Our Ref: BRD-L-Qantas-0001

Thursday, July 4, 2019

Comment on Qantas Flight Training Centre Proposal (SSD 10154)

Figure 6 Overland flooding under existing conditions for 1% AEP event

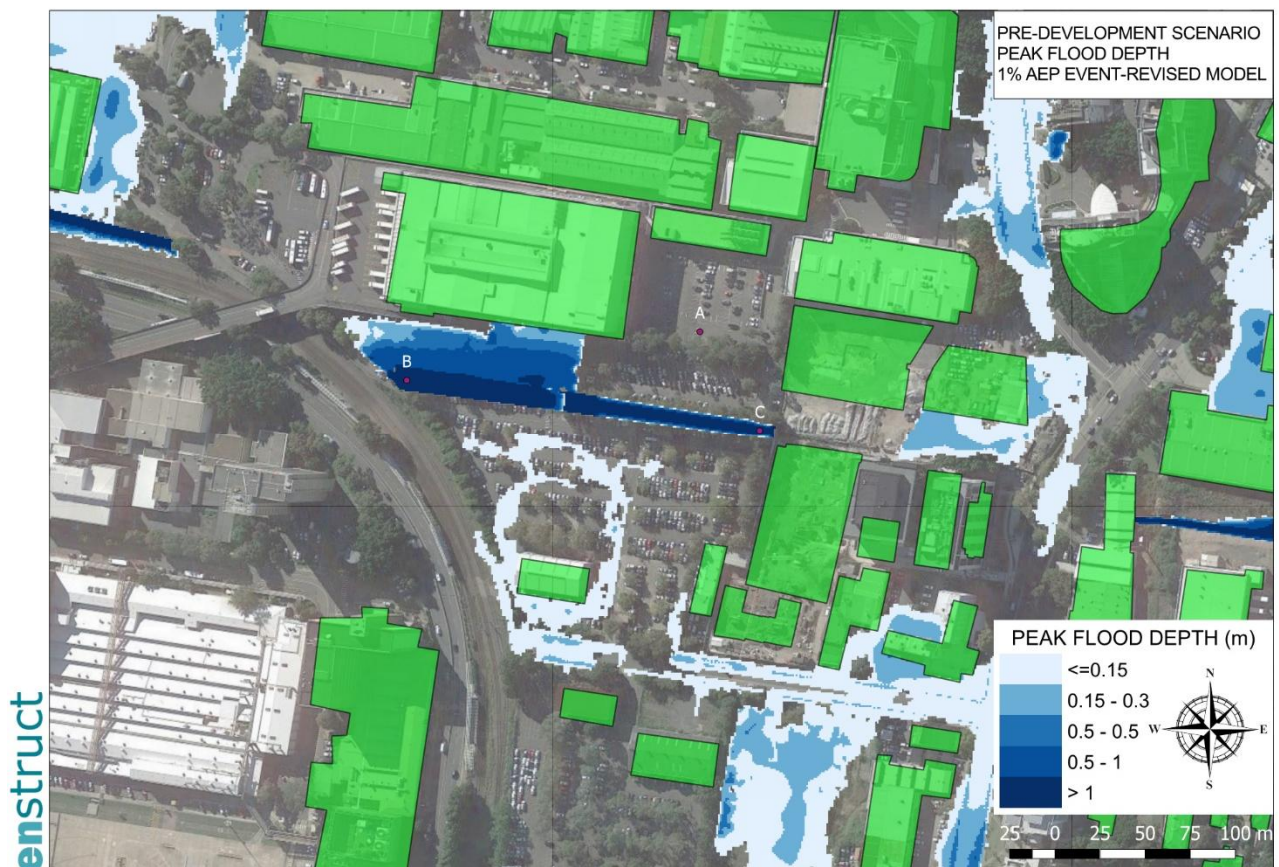
to safety of ARTC infrastructure, operations and people are not introduced as a result of this proposal.
11	Appendix Y - Stormwater Management and Civil Design Report Section 5 - Civil Engineering	<p>Fig 6 shows existing condition (pre-development) modelling only. The proponent should provide the post-development TUFLOW maps shown for 1% AEP to allow ARTC & Council to assess the impacts on the Botany Line for DPE to adequately understand the potential impacts onto ARTC rail corridor.</p> <p>ARTC does not support any impact as a result of increased stormwater overflow onto its rail corridor as it could significantly impact operations to and from Port Botany.</p>
12	Stormwater Drainage Design Appendix A	The stormwater design within the development appears not to contain any on-site stormwater detention / attenuation devices to manage peak flows in to receiving systems. ARTC raise concerns with the increase in 1%AEP and PMF levels at Point B, Section 5 (Fig 6) & Table 3 of the same section.
